Office of Environment & Heritage

Your ref 06_0025 Mod 5
Our reference: DOC13/6645
Contact: Miles Boak 6229 7095

Re Subject: s75W Modification 5 for Stage 1 of Vincentia District Town Centre (MP06_0025)

The Office of Environment and Heritage (OEH) has reviewed the s75W Modification and provides the following comments:-

TEMPORARY REVEGETATED LANDSCAPE

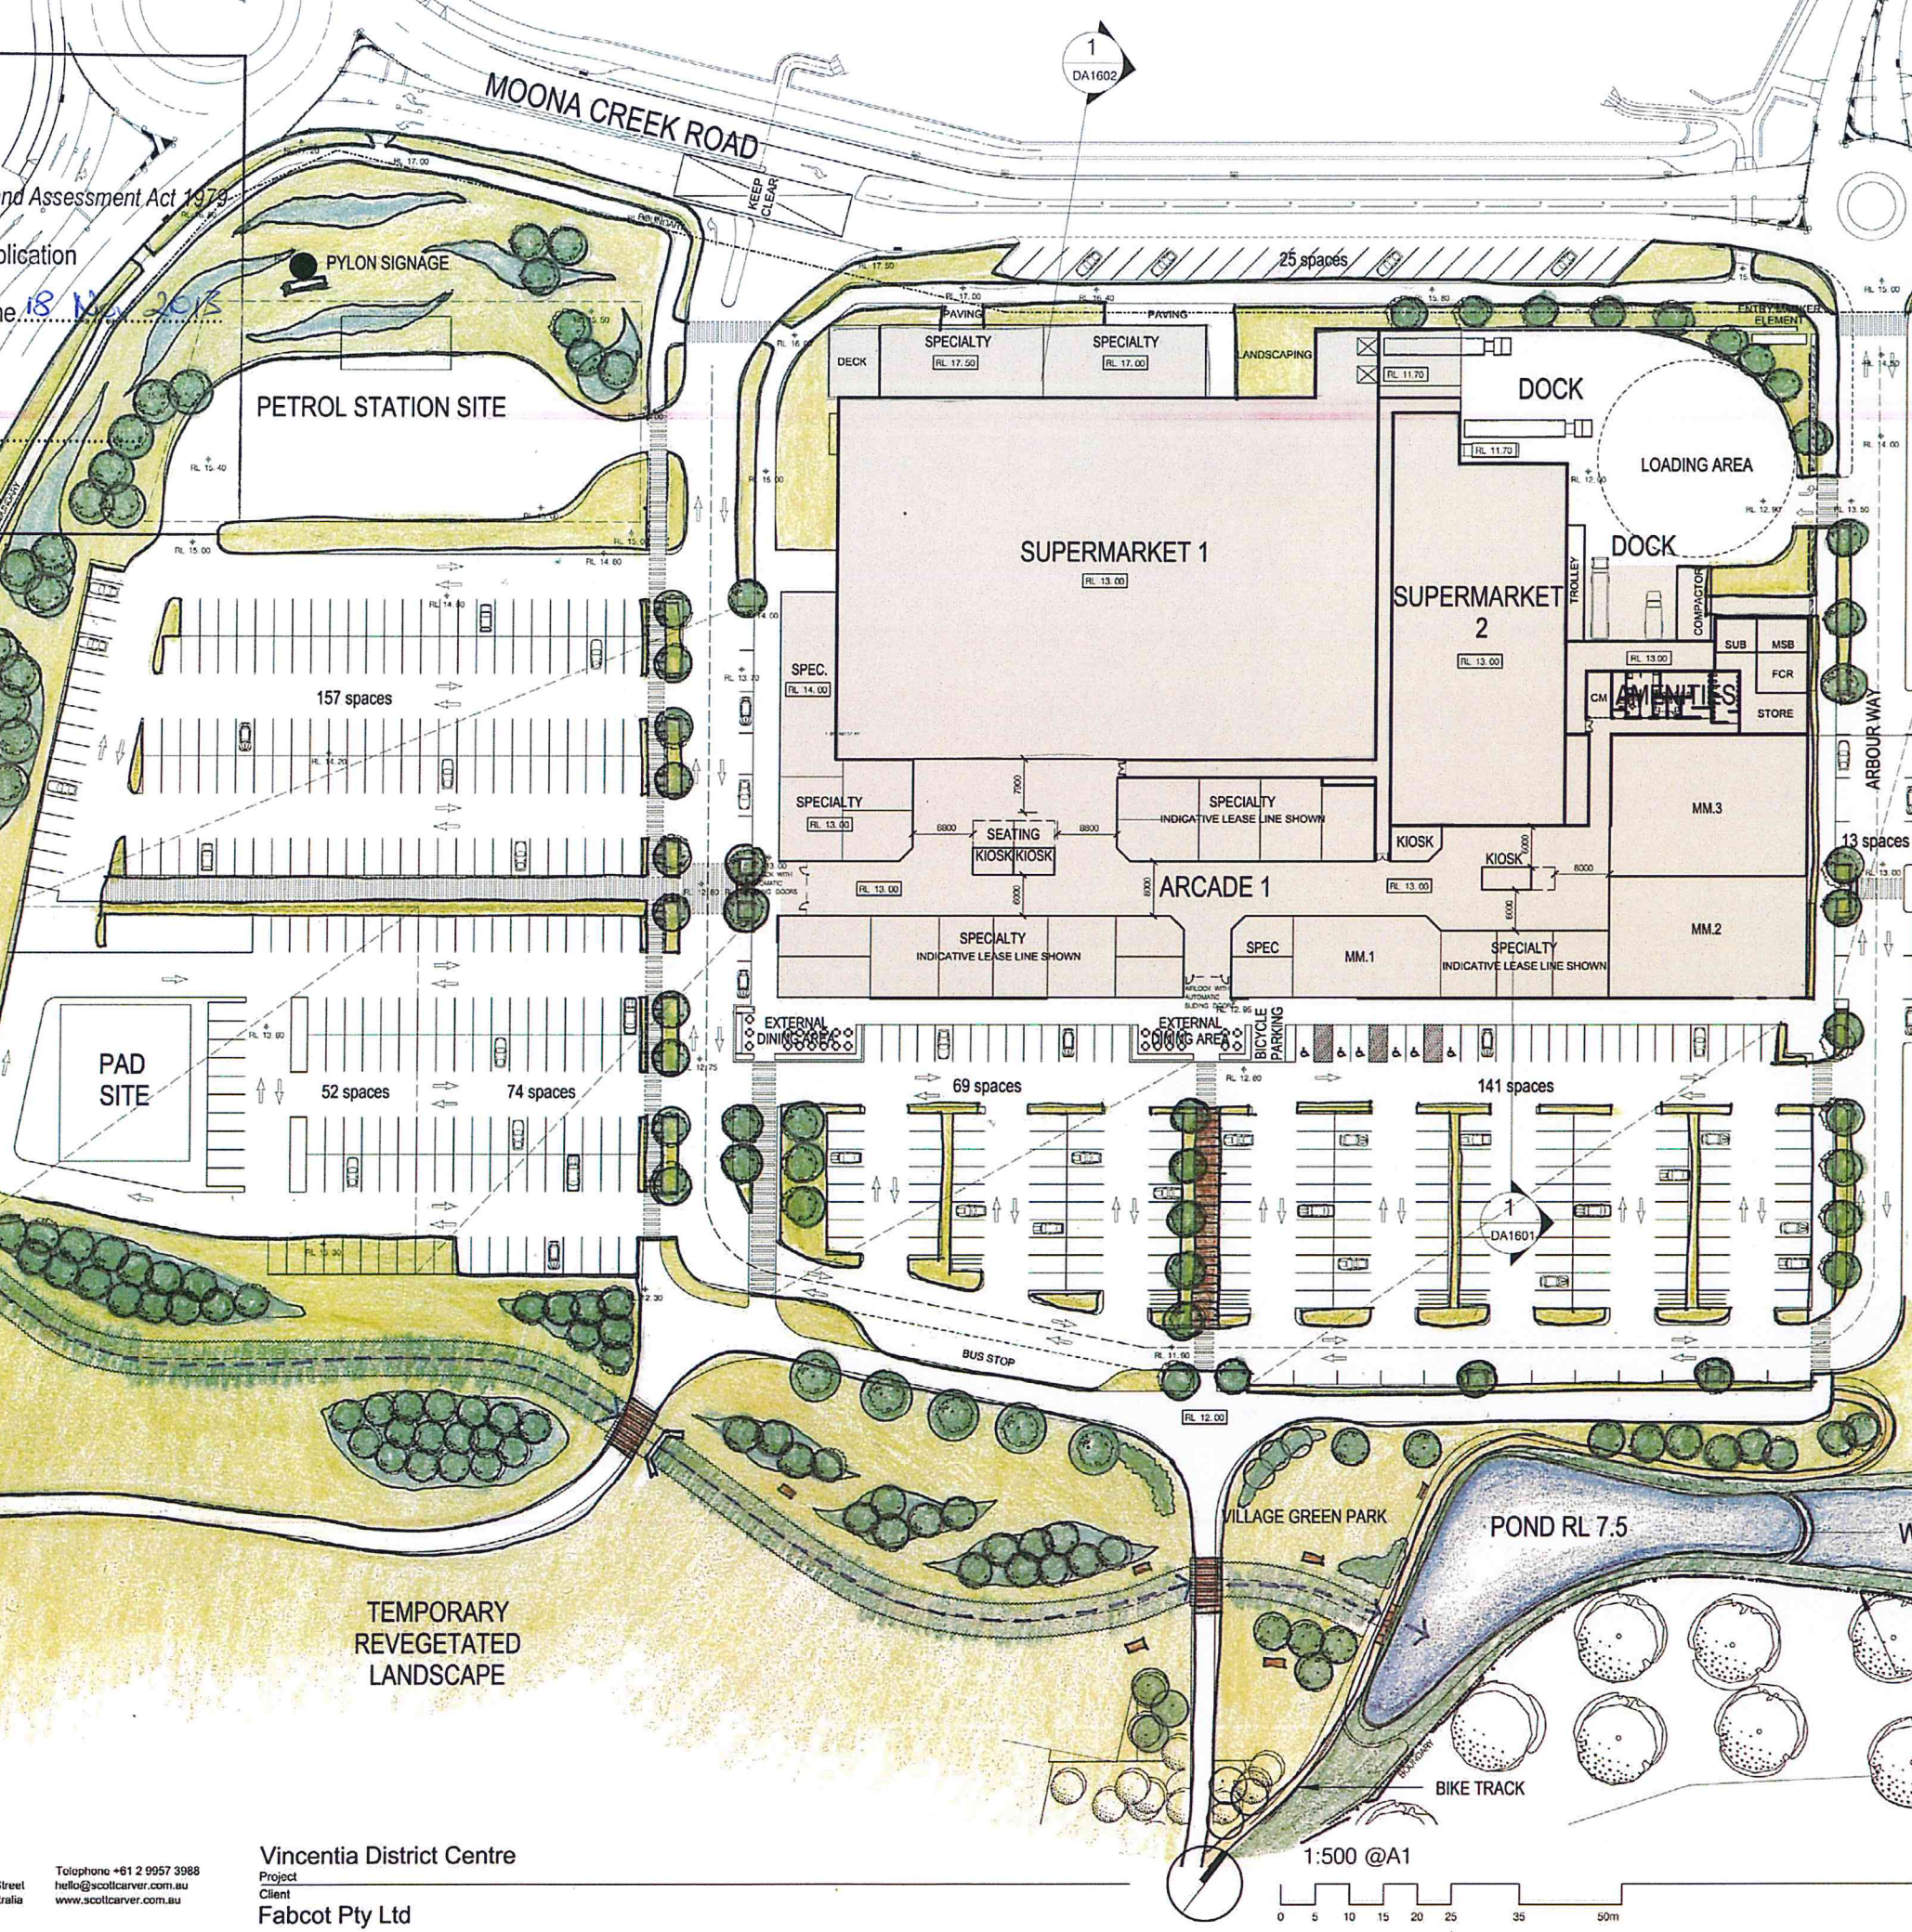
- The plans describe a proposed action, on the balance of the already-cleared commercial-zoned land, to instigate a "*temporary revegetated landscape*". There is no detail as to what this term means, or what actions are proposed to bring this about. OEH requests greater detail on this proposal before any comment in made. OEH is concerned to ensure that the remainder of the site is assessed for the need for rehabilitation, especially where exposed ground still exists, and on the creek line that runs through the site, to reduce the potential for erosion, and invasion of exotic weeds. OEH notes that from a recent site visit, the ground layer in this area seems to be regenerating naturally, but this regeneration is unlikely to result in the complete re-instatement of the ecological community that was previously present on site, certainly not in the short to medium term.
